EL PASO COUNTY

DEPARTMENT OF PARKS AND COMMUNITY SERVICES

Subject: Retreat at TimberRidge Filing No. 3 Final Plat, Review #3 (SF-22-041)

The Parks Planning Division of the Parks and Community Services Department has reviewed the 3rd submittal of the Retreat at TimberRidge Filing No. 3 Final Plat development application and has the following additional comments of behalf of El Paso County Parks:

RETREAT AT TIMBERRIDGE FILING NO. 3
CONSTRUCTION PLANS
STREET IMPROVEMENT PLANS
ARROYA LANE & ASPEN VALLEY ROAD

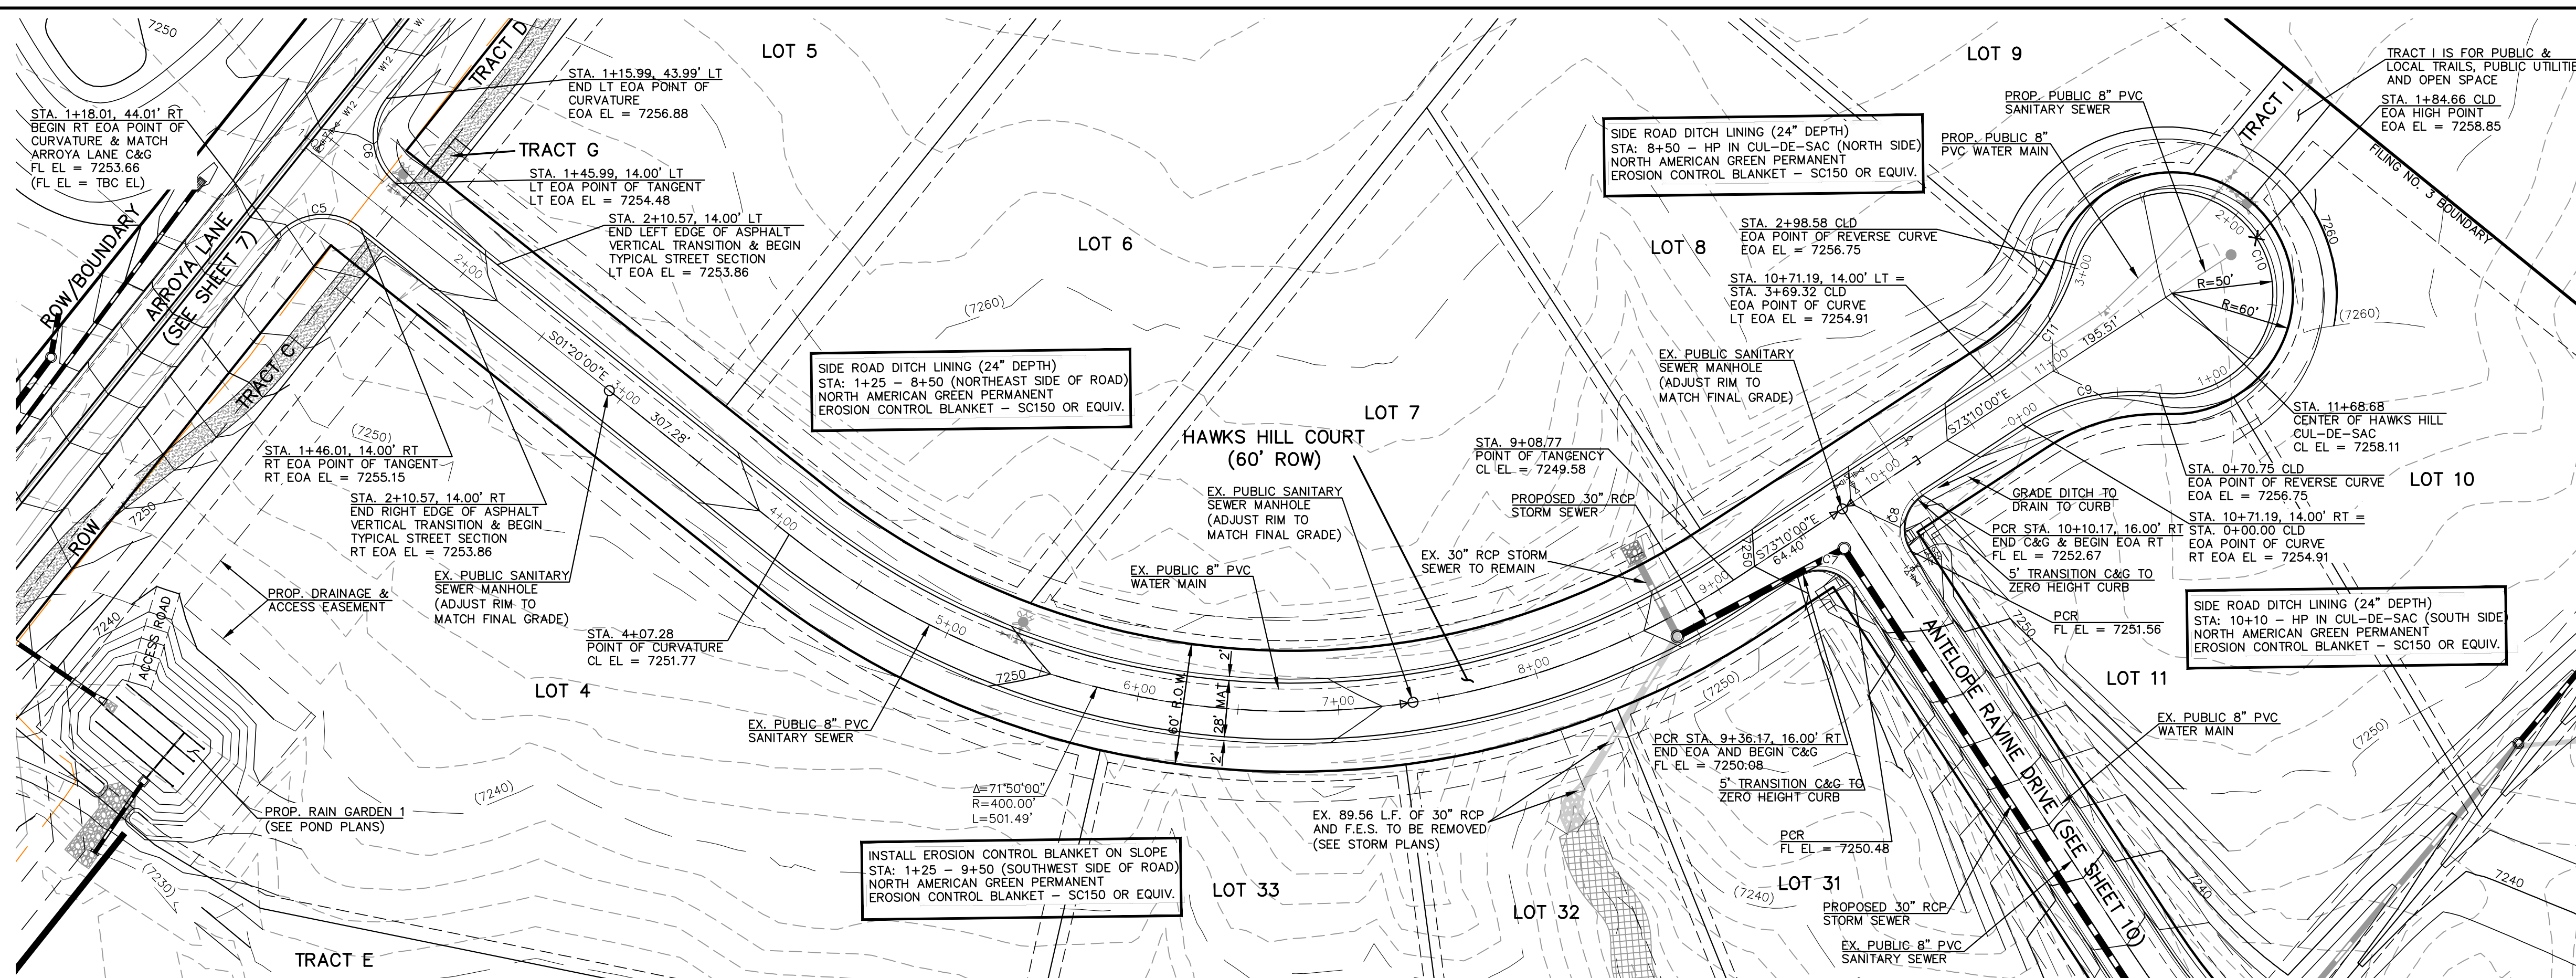
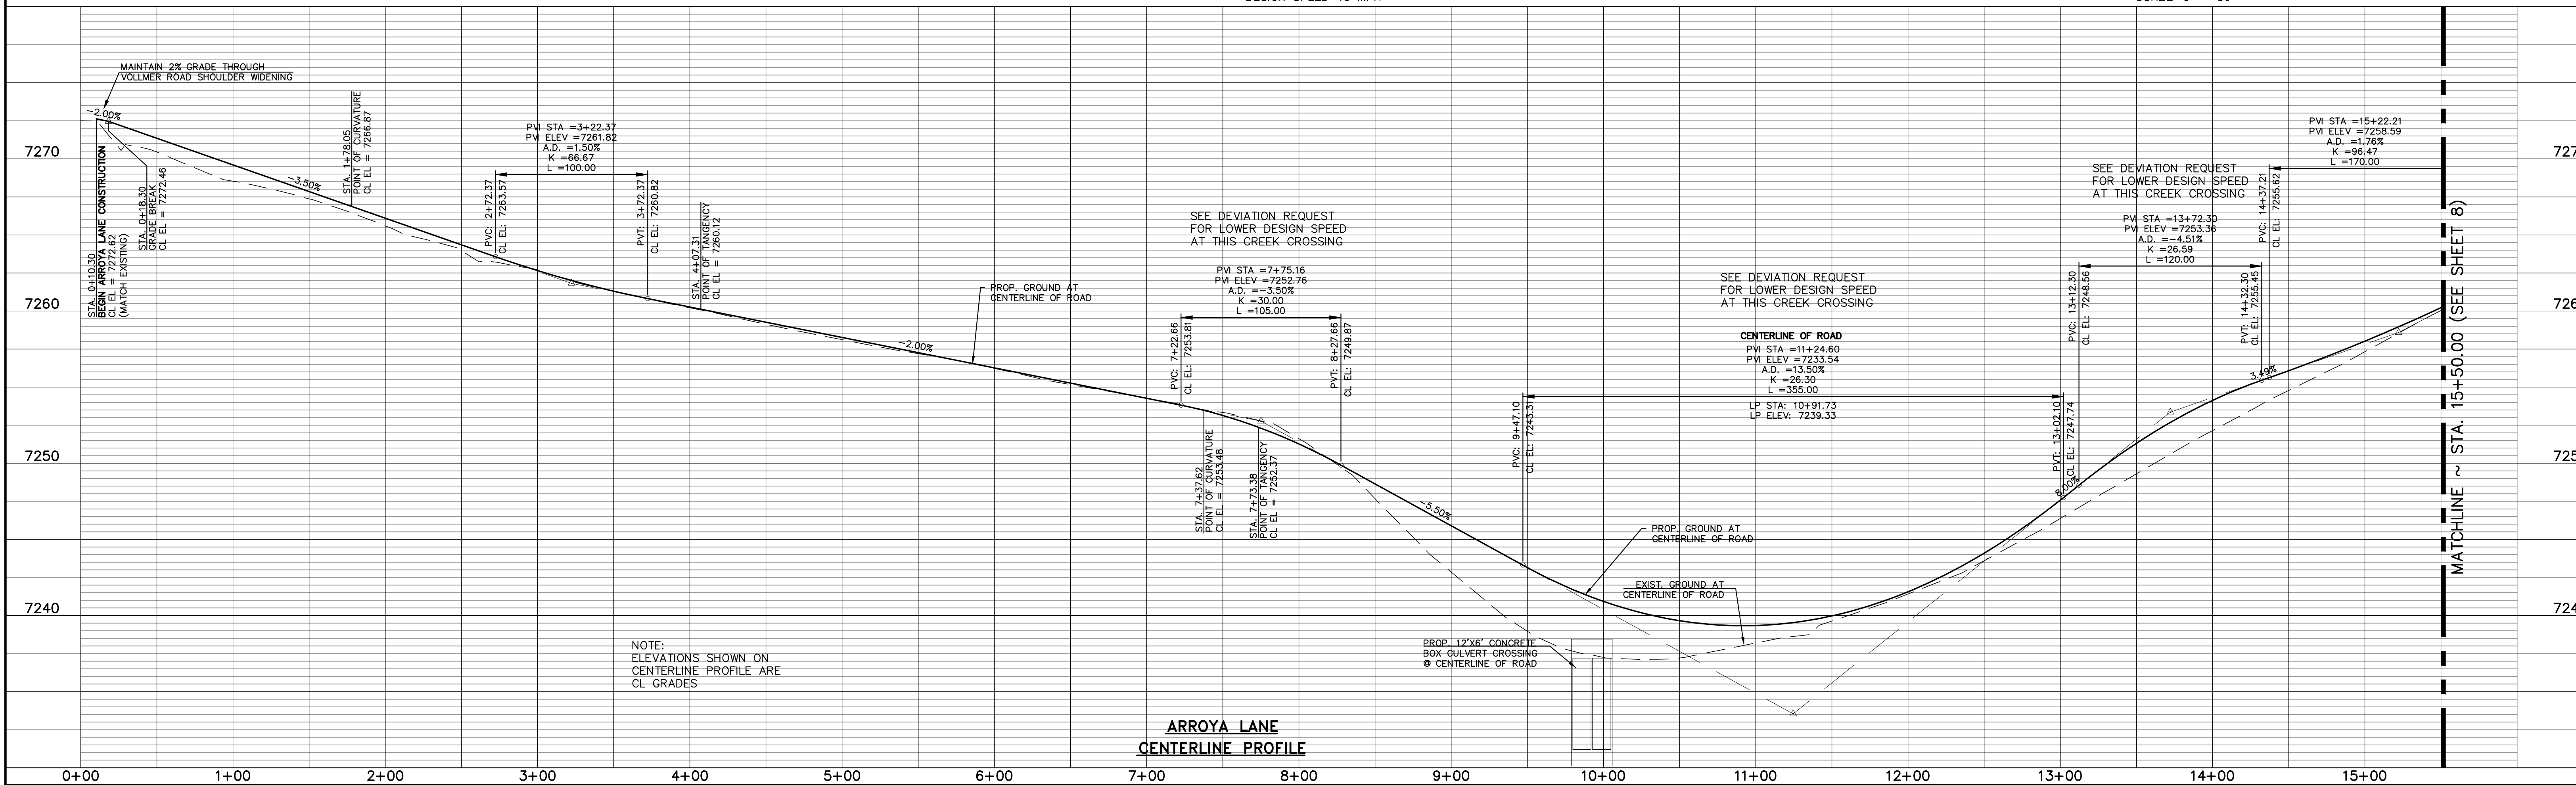
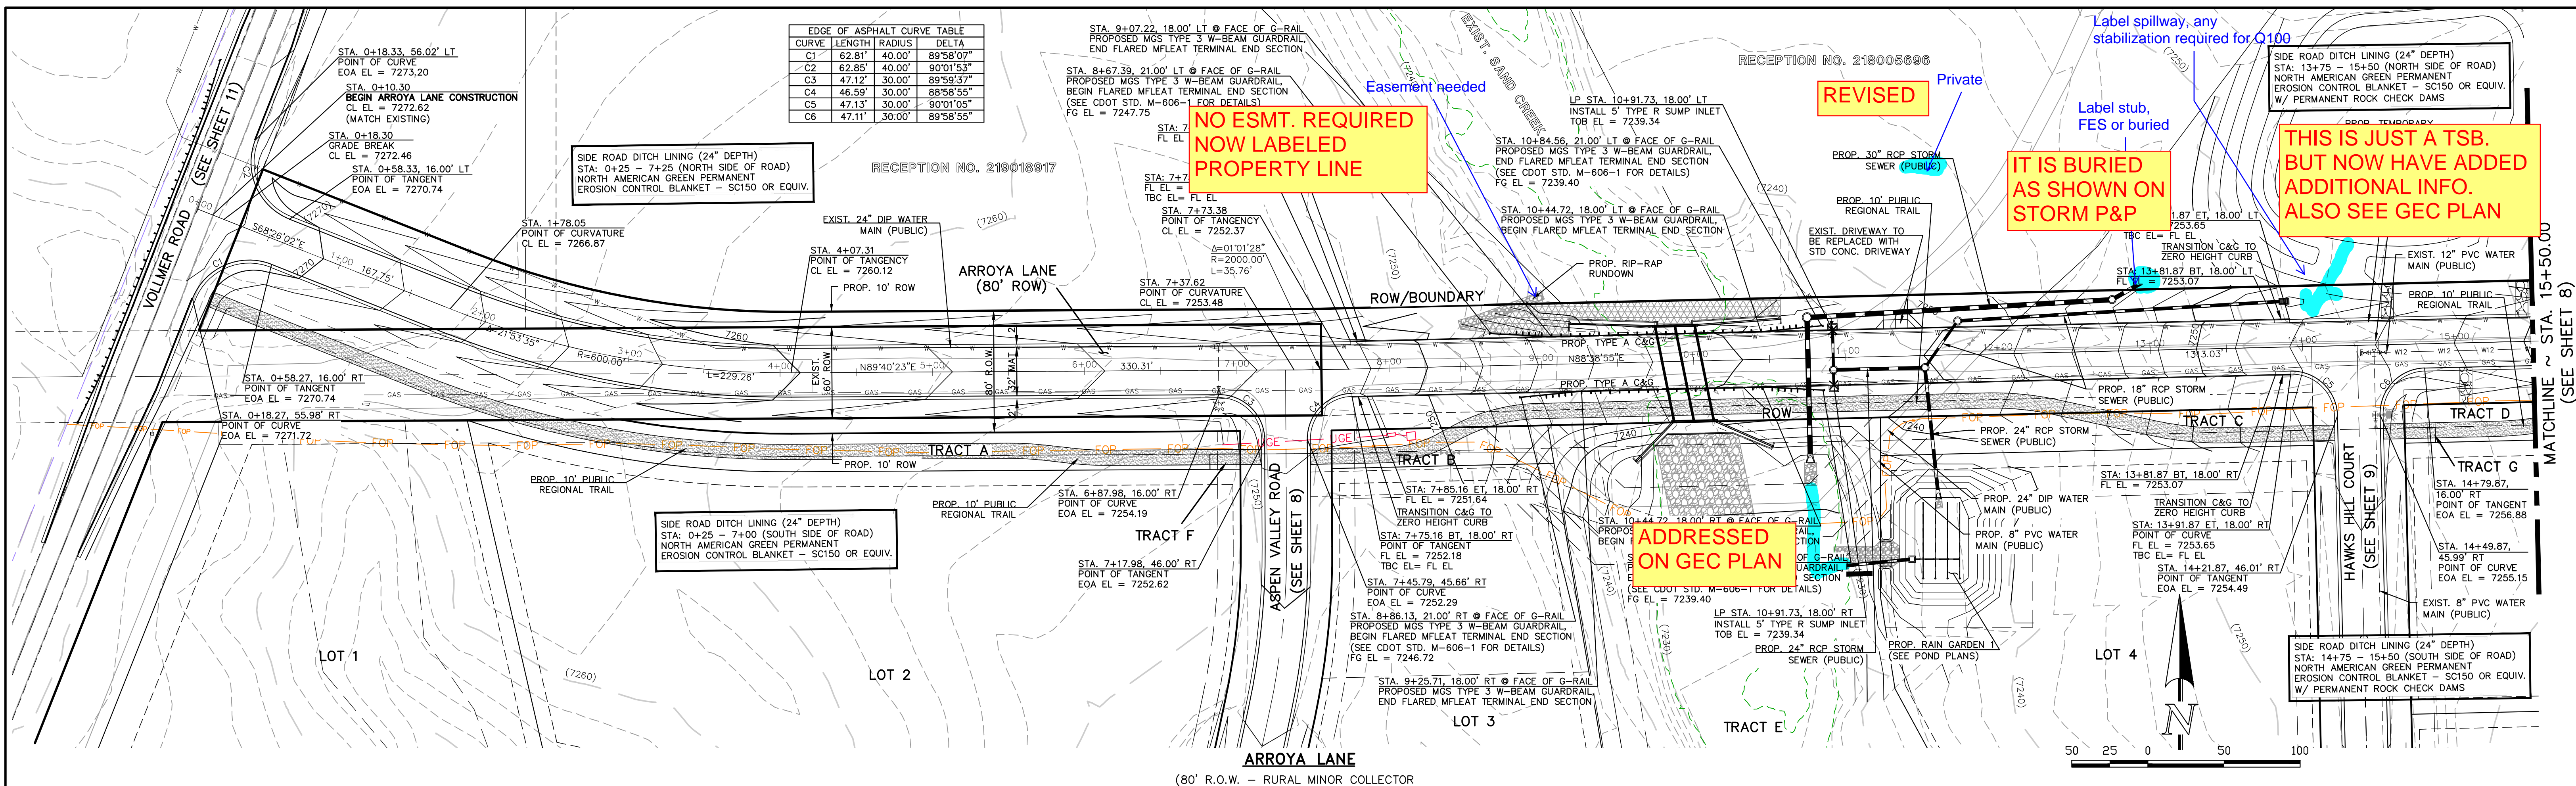
El Paso County Parks needs clarification regarding the following comments, originally submitted administratively on October 20, 2023. It would appear that the sidewalk system on the south side of Arroyo Lane is intended to serve as the primary route for the Arroyo Lane Primary Regional Trail, but at this time, staff needs applicant verification regarding the use of the sidewalk as a regional trail:

***“As noted in the comments and recommendations below and because Tracts A-D are to be owned by The Retreat Metropolitan District No. 1, the applicant must show and label the required 25’ regional trail easements within the aforementioned Tracts. Staff understands that Tract H will be owned by El Paso County and therefore does not require the dedication of the regional trail easement, however, for continuity, the applicant may show a trail easement within Tract H.*”**

***However, if the proposed sidewalk along the south side of Arroyo Lane is intended to serve as the Arroyo Lane Primary Regional Trail, EPC Parks staff requests that it be built to a width of 8 feet to reflect EPC Parks trail standards. According to the construction documents submitted by the applicant, the proposed sidewalk does appear to be approximately 8’-10’ wide, as it appears to be the same width as the proposed 10’ Arroyo Lane right-of-way, although no definitive measurements are included in the plan. Where the sidewalk exists inside Tracts A-D, the trail easement may encompass the sidewalk. No trail easement is necessary within the Arroyo Lane ROW, where the Arroyo Lane culvert crosses Sand Creek.*”**
